Kevin O'Hanlon
Department for Transport
Great Minster House
33 Horseferry Road
London
SW1P 4DR

Date 27 August 2021
Our ref GOWL/047664.0051/GOWL
Direct Dial [REDACTED]
Direct Fax [REDACTED]
Email [REDACTED]@wedlakebell.com

Application by North Somerset District Council ("the Applicant") for an Order granting Development Consent to construct a new railway on the trackbed of the former branch line from Bristol to Portishead including associated works ("the Proposed Development")

Request for comments from the Applicant and Bristol Port Company

Drawn by: ADS	Date: 03/02/2016
Checked by: AL	Date: 08/04/2016
Approved by: AL	Date: 08/04/2016
Drawing No.	Revision
467470.BQ.04.20-553	E

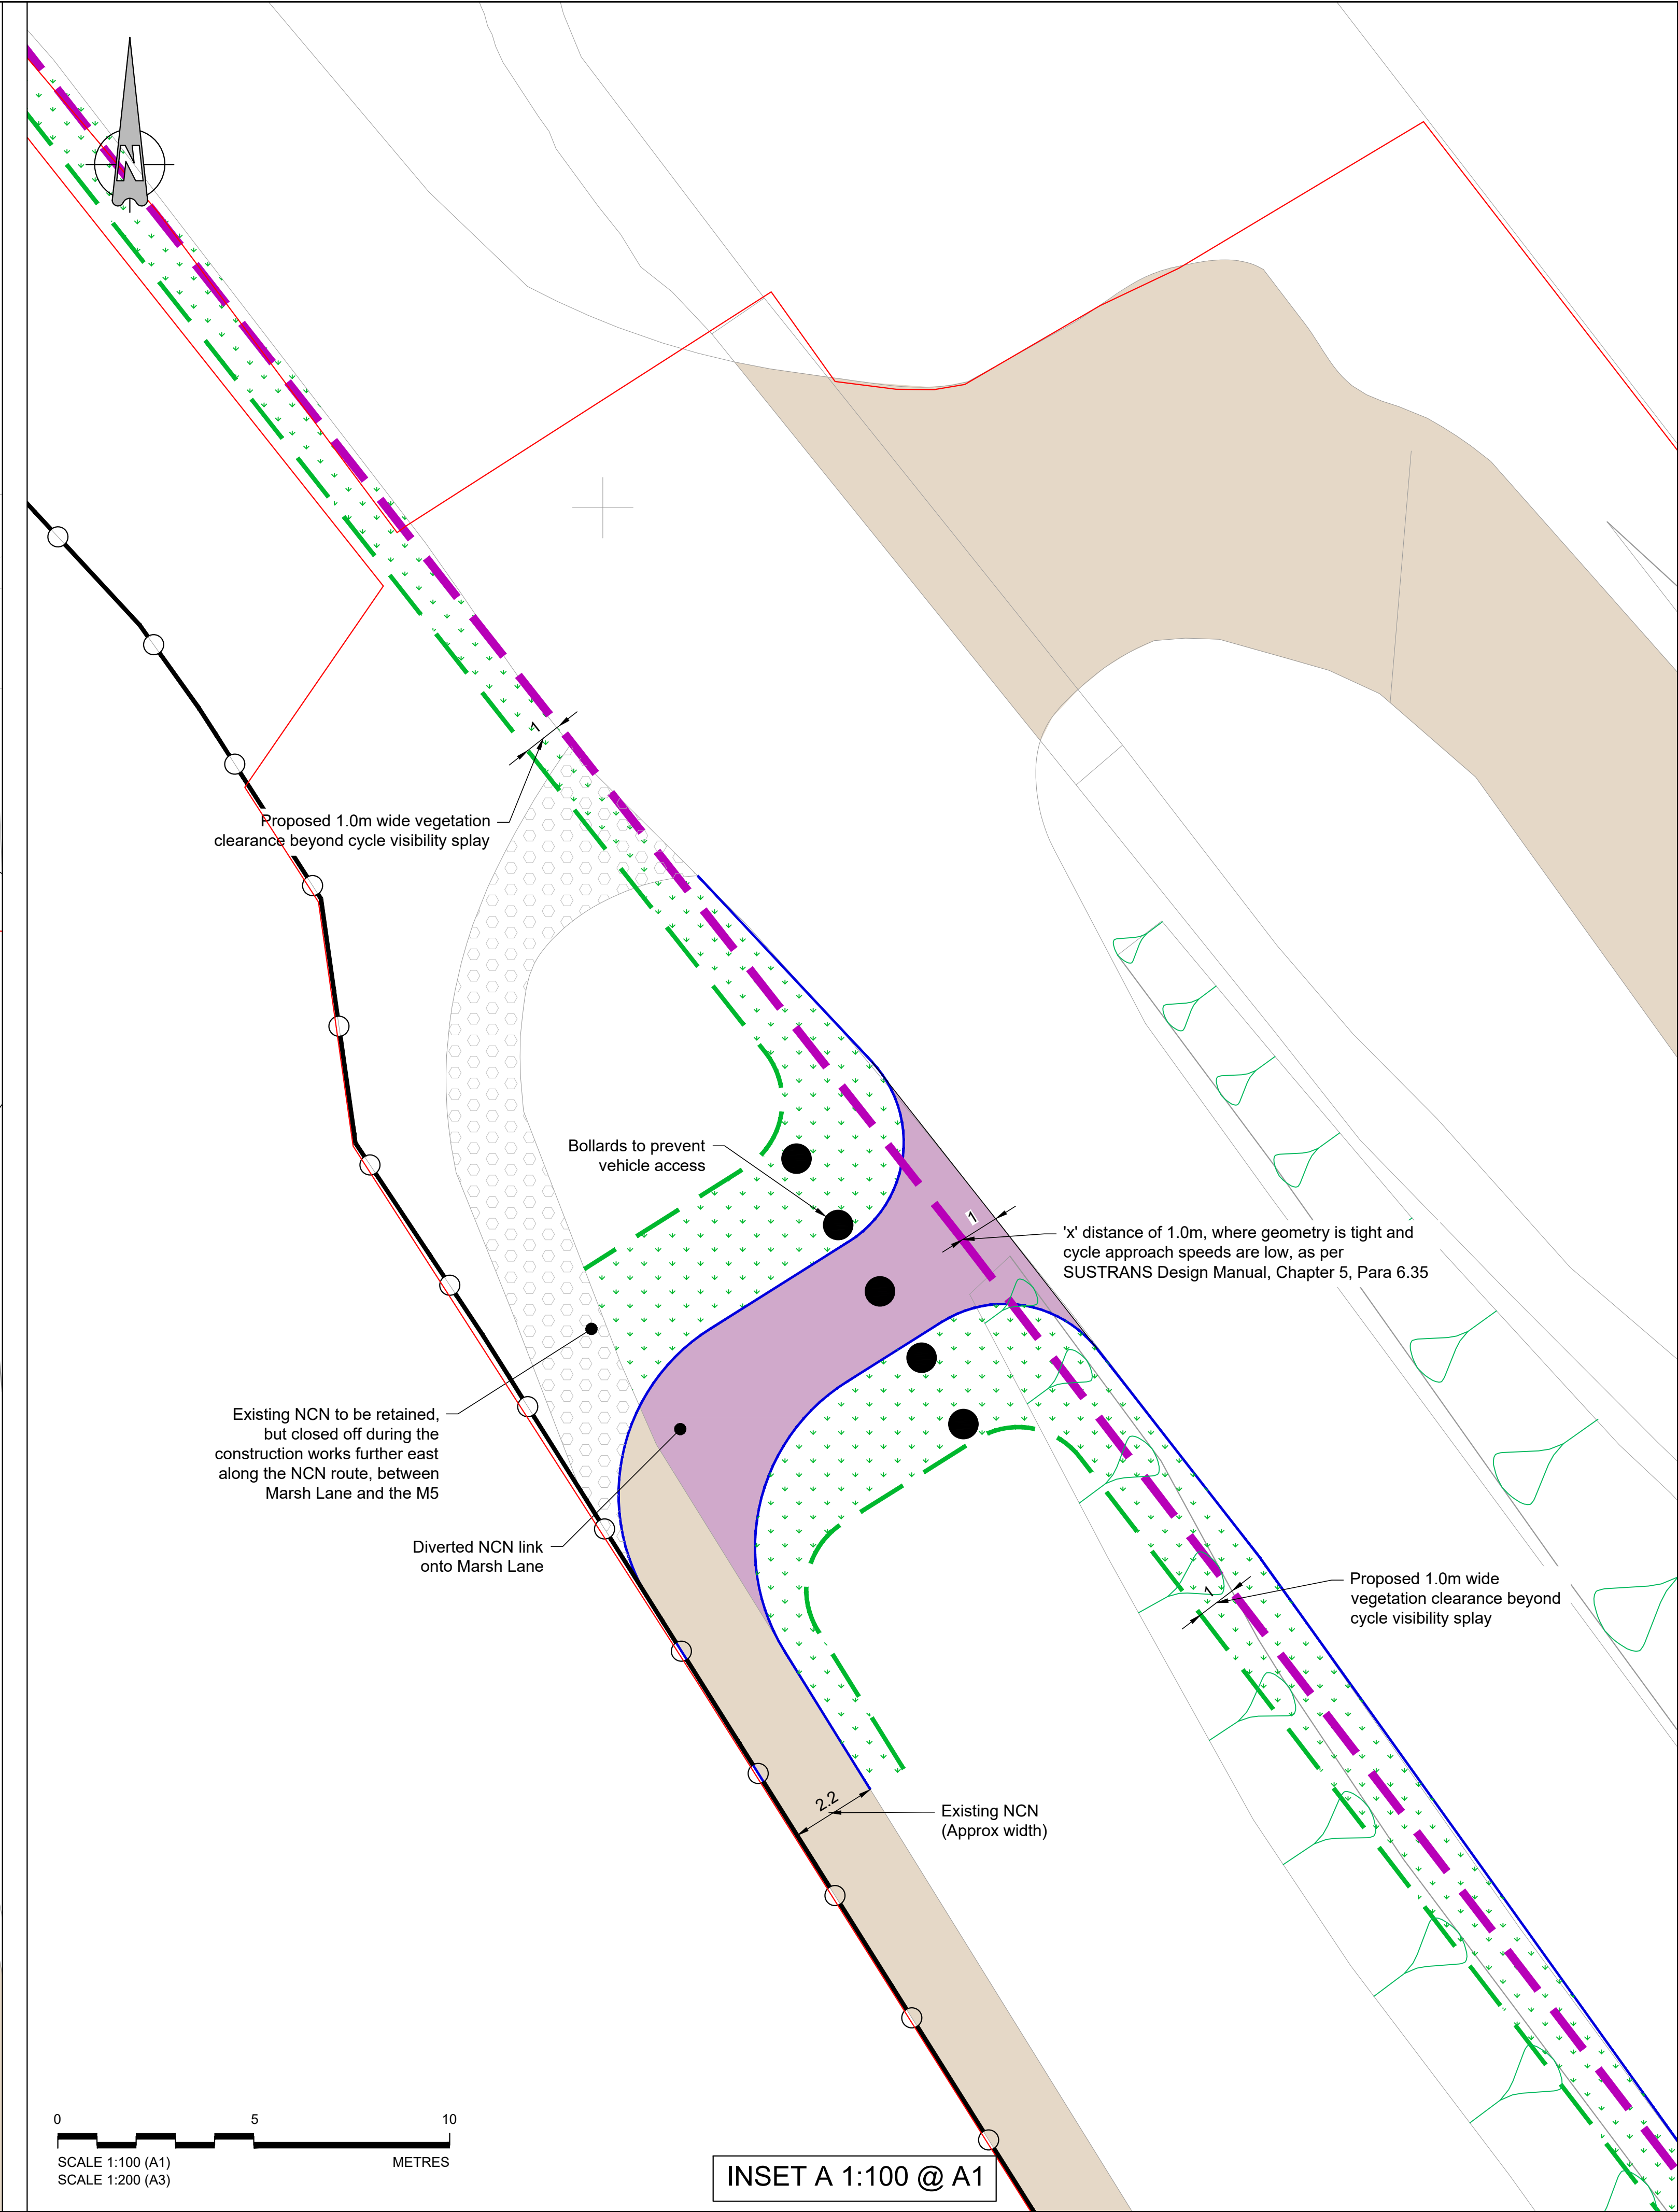
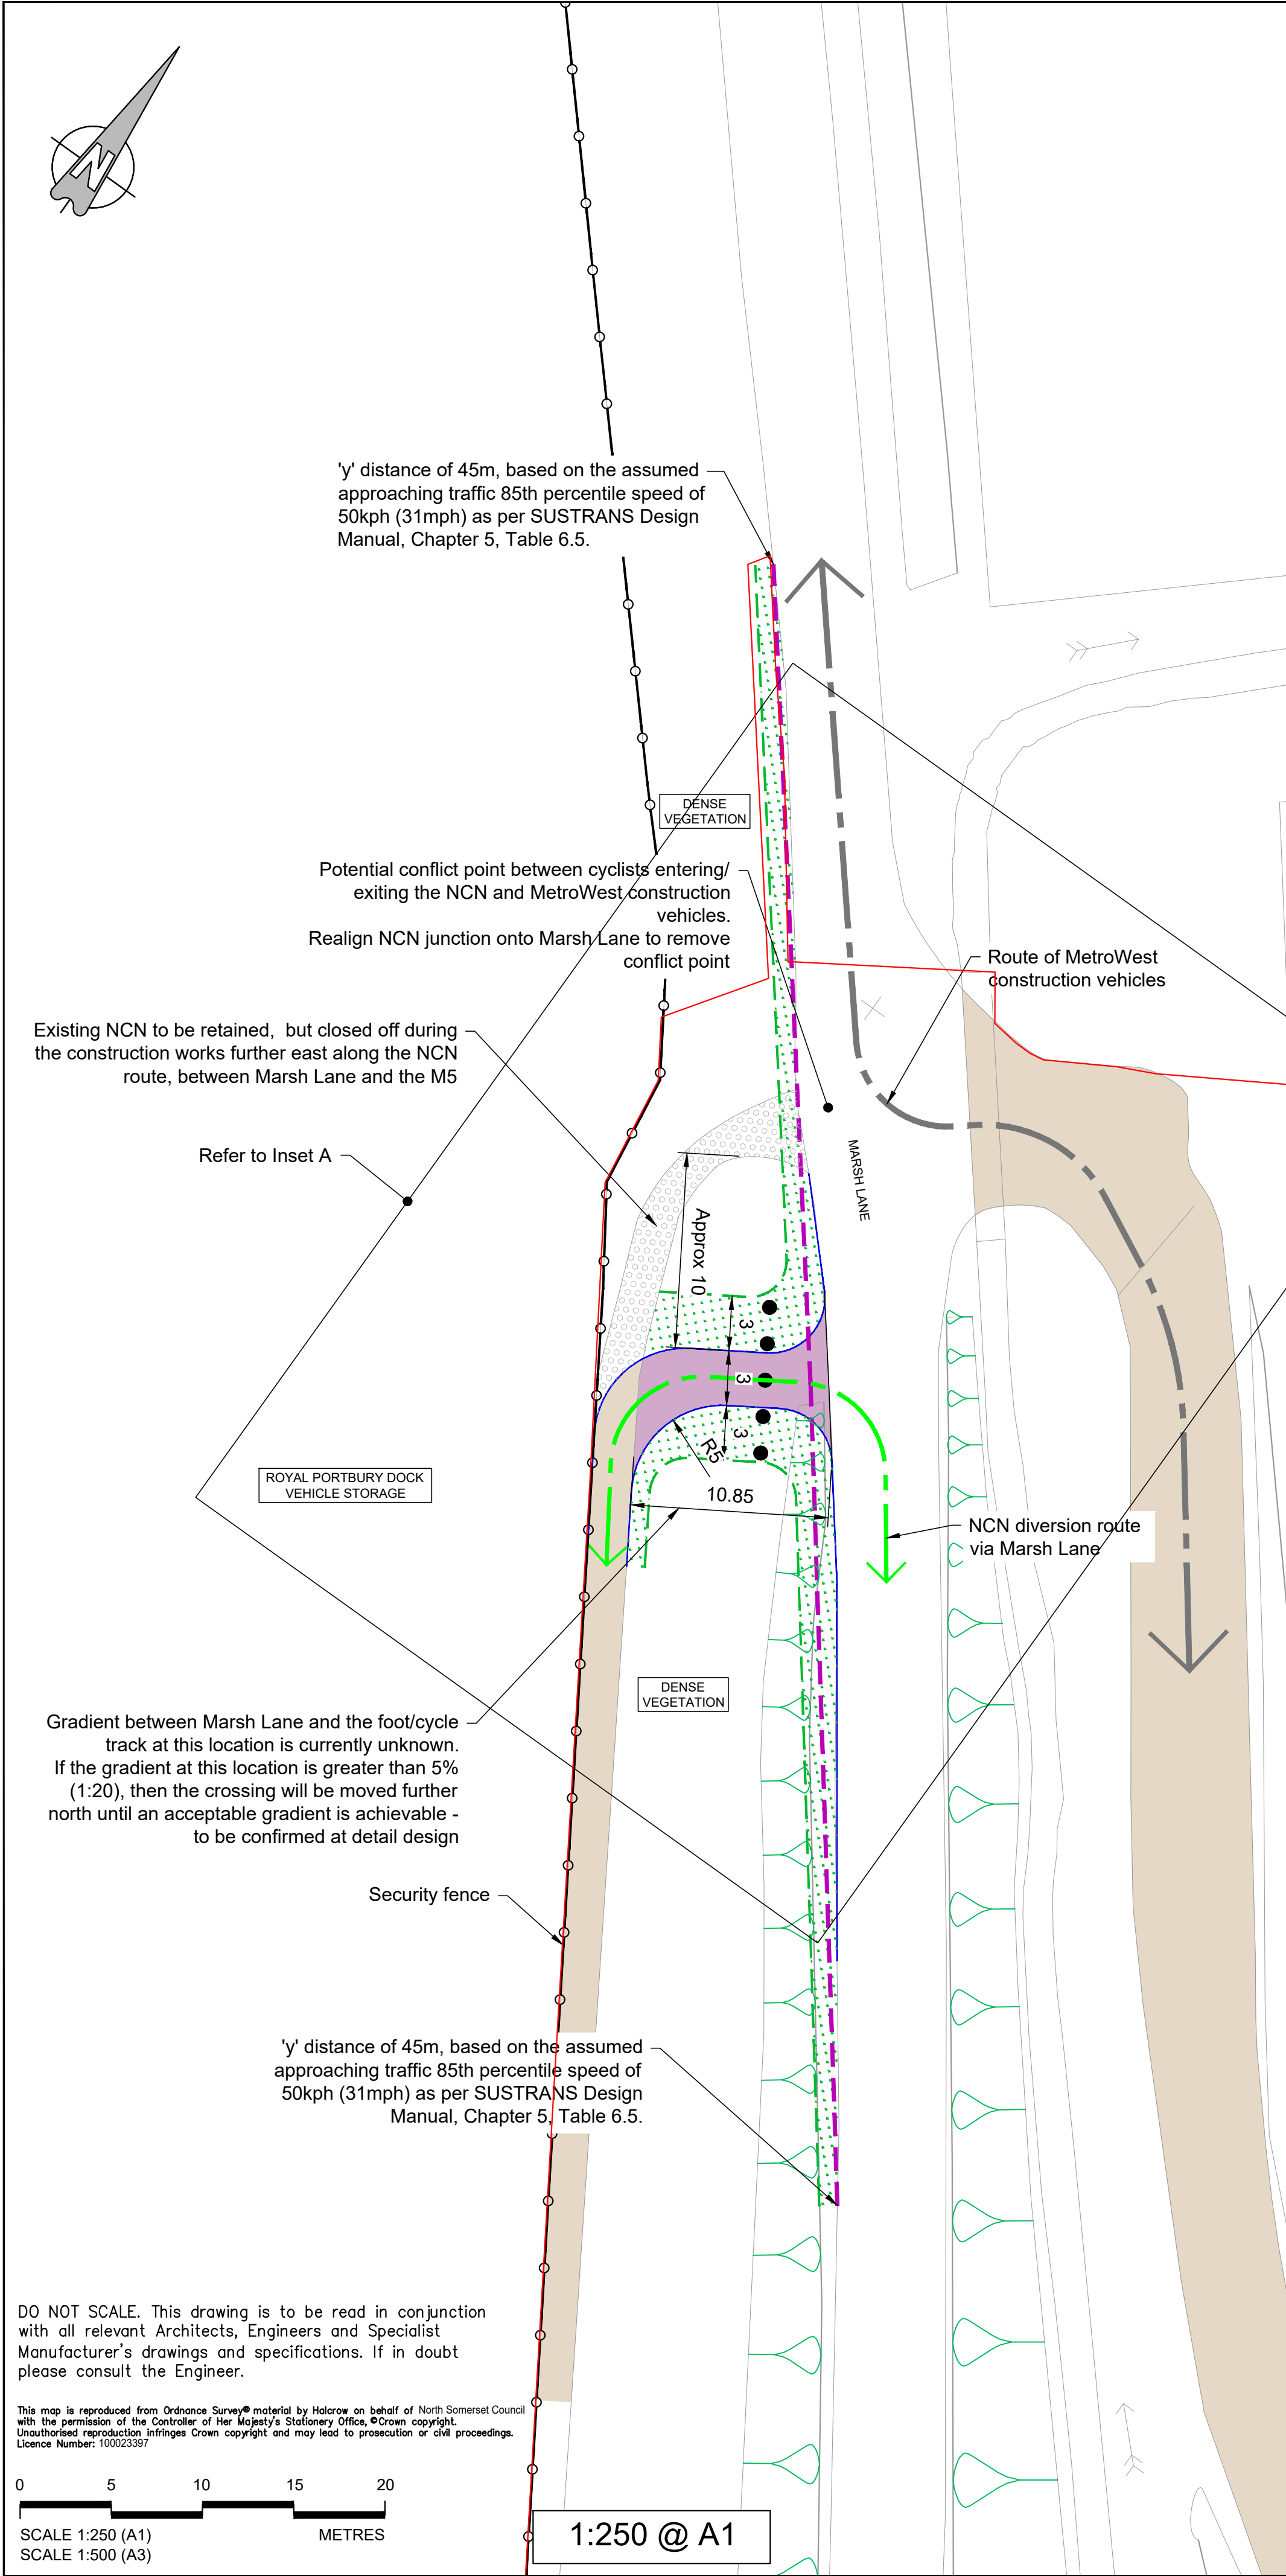
6. The Applicant states that Work No. 16 is an "*integral part of the [DCO] project*", providing a diversion of part of NCN26. BPC disagrees and considers that it is not necessary to carry out Work No. 16 as part of the DCO project or at all. The current path which the Applicant seeks to divert is a permissive route only, and itself constitutes a short diversion from the main route of the NCN over the established PROW network: from west to east the diversion leaves public bridleway LA8/66/10, passes under Marsh Lane and alongside the railway to re-join public bridleway LA8/67/10 at a point east of the proposed location of Work No. 16. If the Proposed Development were to cause Network Rail to withdraw its permission for use of this short diversion, the existing public bridleways, connecting across Marsh Lane, provide an adequate alternative route which the Applicant's drawings show is already regarded as part of NCN26 (see drawing 467470.BQ.04.20-554 in DCO document 2.37).

7. Even if some diversion of the permissive route were necessary (which BPC does not accept), or desired BPC questions why the proposed realignment of the route of the path to the north under Marsh Lane to avoid the new track bed could not have been continued further eastwards so as to connect with the NCN on public bridleway LA8/67/10 at approximately the same place as that connection is made now. This would have avoided the division of BPC's land currently proposed by Work No. 16.

8. Despite its views above, BPC is willing to accommodate a path as proposed by Work No. 16, provided it is constructed in accordance with the current drawings and that the resulting path is a permissive route only. However, in the absence of any necessity for Work No. 16 either at all or on its proposed alignment, BPC considers it is not appropriate for the Order to contain powers of compulsory acquisition in respect of its proposed site (plot 5/27) affecting BPC's land which it uses and/or holds for the purposes of its statutory undertaking: see paragraphs 15 to 17 of BPC's CA note. Similarly, nothing in the Order should give the Applicant power to create Work No. 16 as a path open to the public without BPC's agreement through the creation of a permissive path in the agreed location.
